Scoping document application reference: 22/03763/SCOP

Please find below comments submitted to Begbroke parish council by residents and by councillors and agreed to be submitted at PC meeting 6th February 2023

Figure 5.1: Existing Public Rights of Way Network

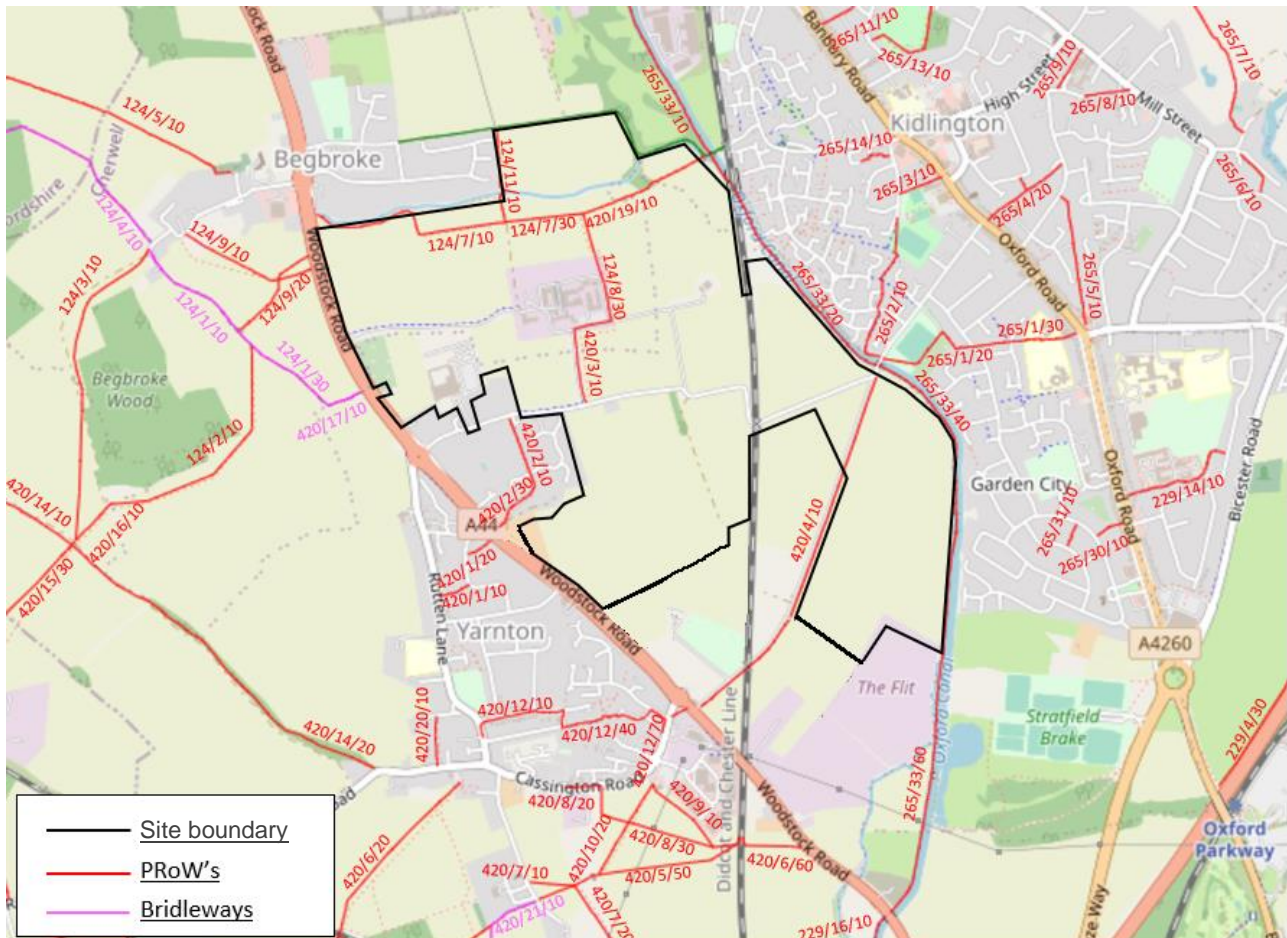
Section 7.6 and Figure 5.1, Parker's Farm is not shown on footpath map. Parish council are pursuing this
